CARTESIAN SURVEYS INC agent(s) for JOHN DARK request(s) the above action(s) for all or a portion of Lot(s) 1, Block(s) 1, **GENTRY ADDITION** zoned M-1, located on 2ND ST BETWEEN CLAREMONT AND MILDRED containing approximately .7174 acre(s). (H-14) **THE SKETCH PLAT WAS REVIEWED AND COMMENTS WERE PROVIDED.**

**CITY OF ALBUQUERQUE  
PLANNING DEPARTMENT  
May 15, 2013  
DRB Comments**

**PROJECT # 1009693**

**RE: Lot 1, Block 1, Gentry Addition**

**Plat for  
Lot 1-A, Block 1, Gentry Addition  
Being Comprised of  
Lot 1, Block 1, Gentry Addition  
City of Albuquerque  
Bernalillo County, New Mexico  
June 2013**

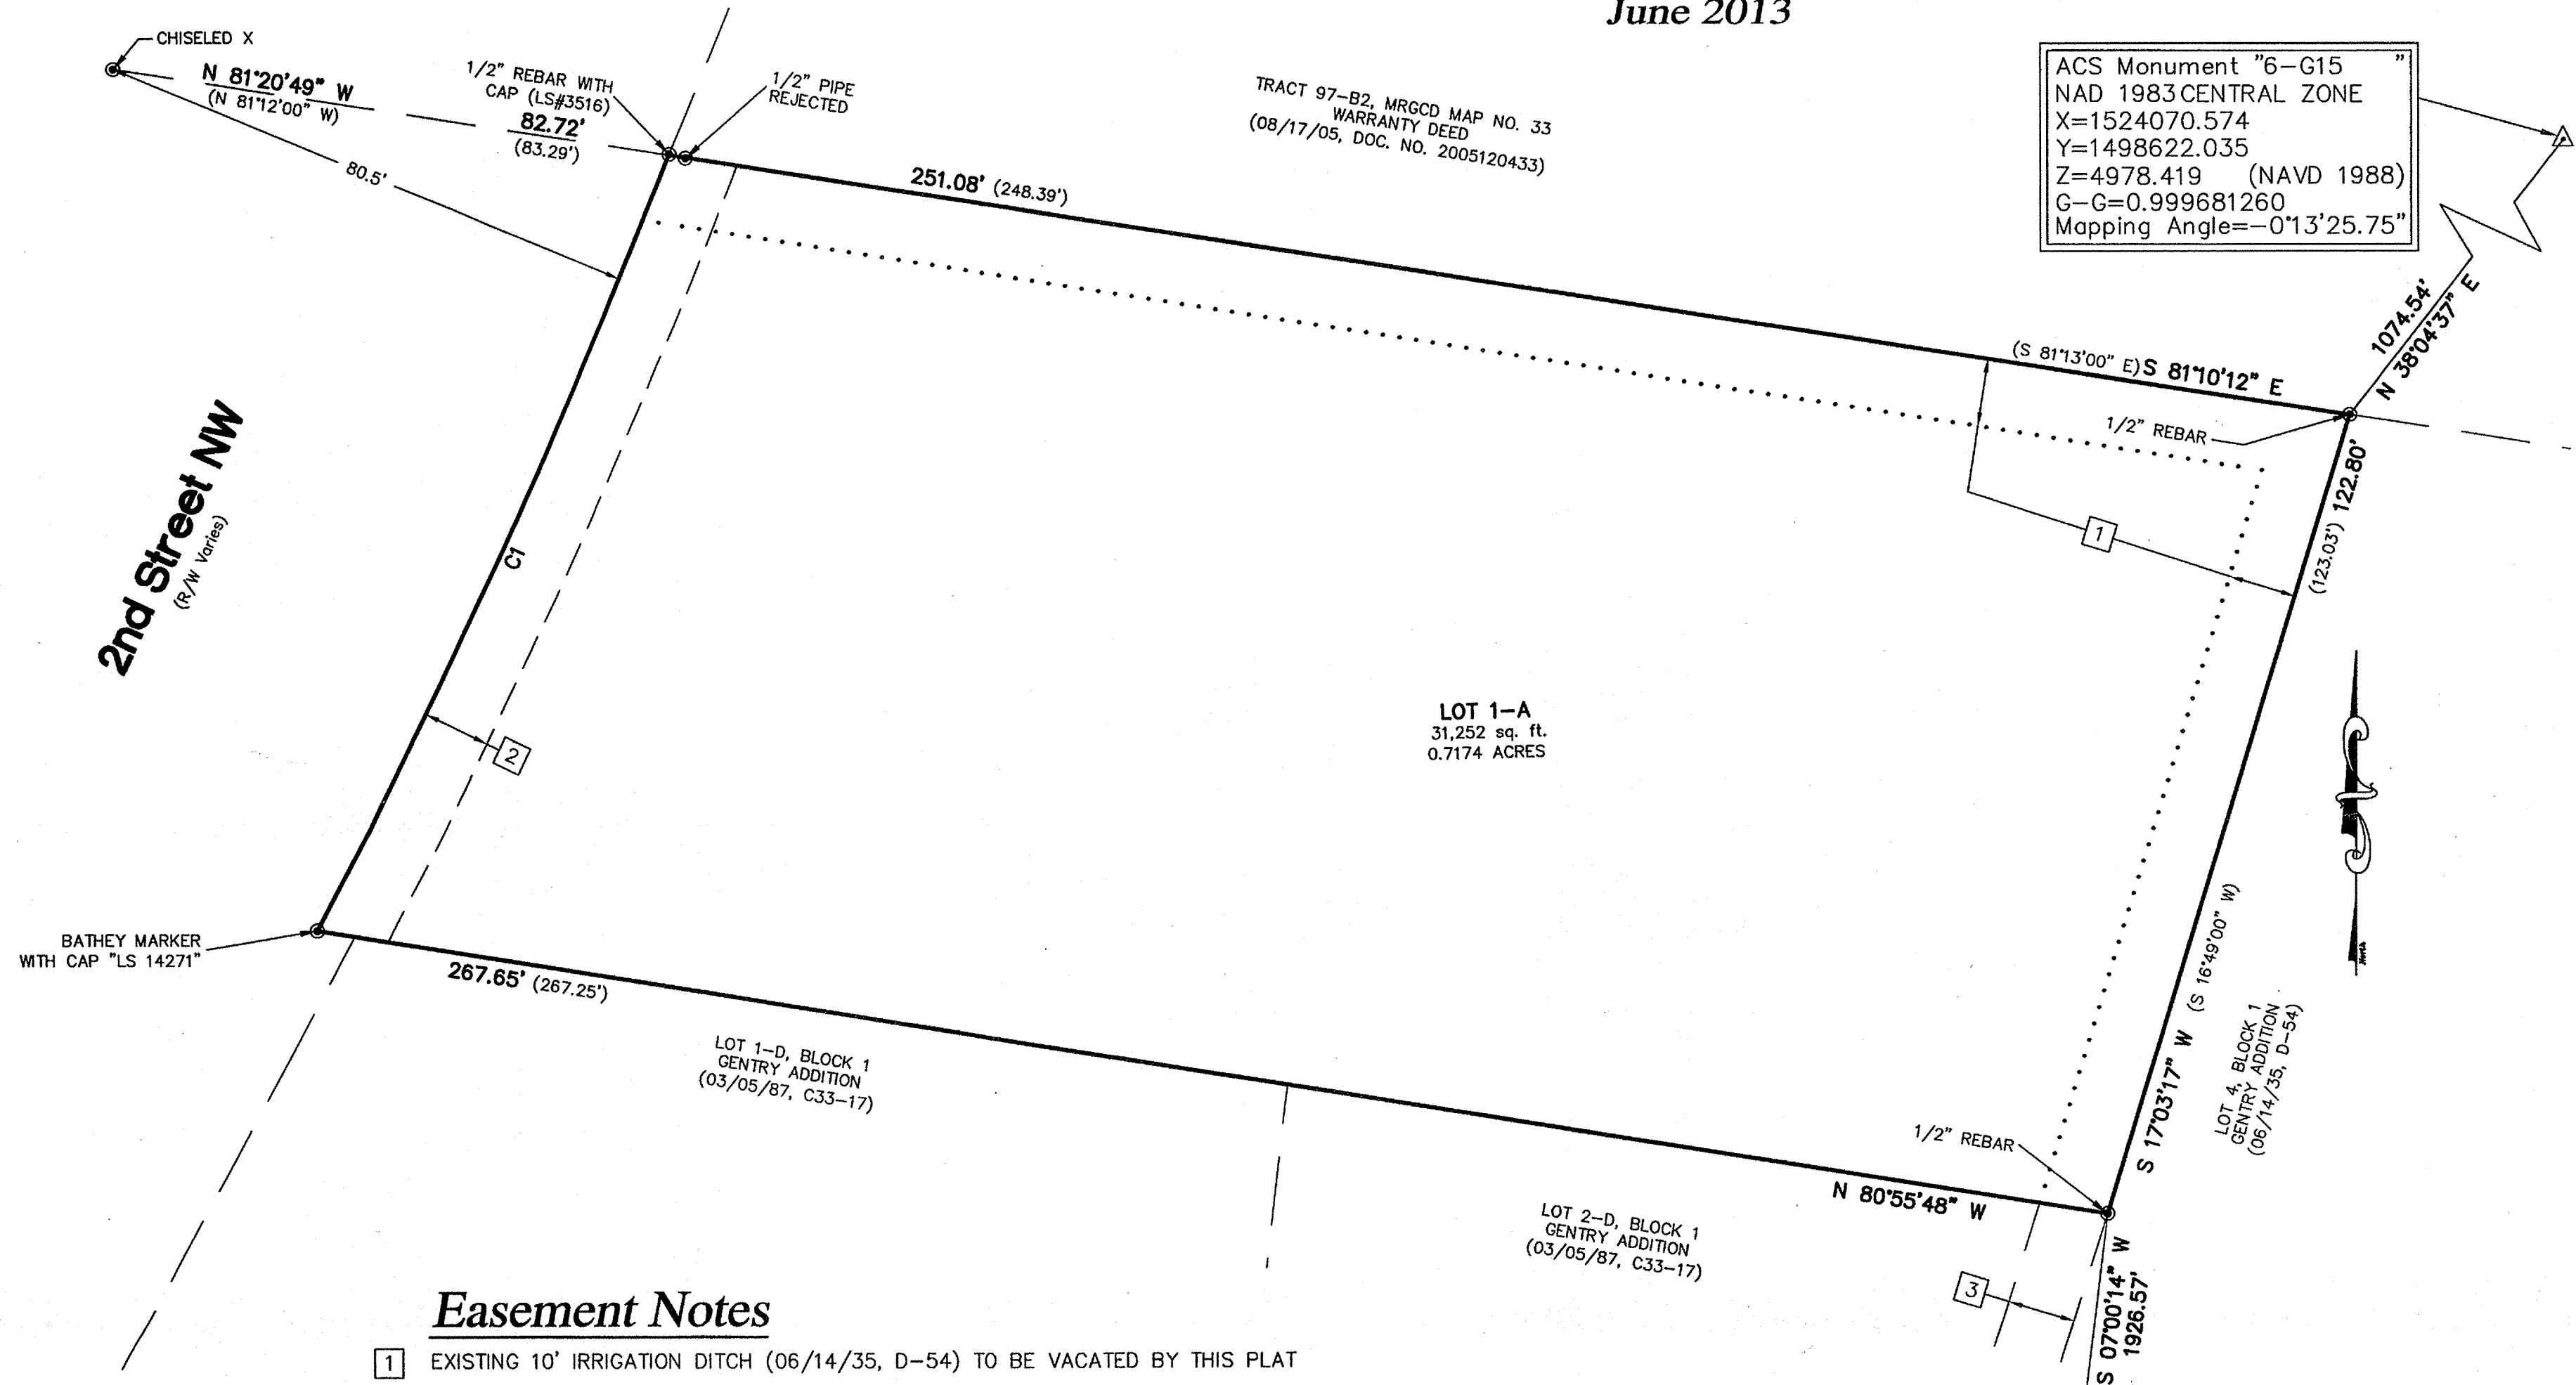
'An advertised public hearing is required for vacation of easement.
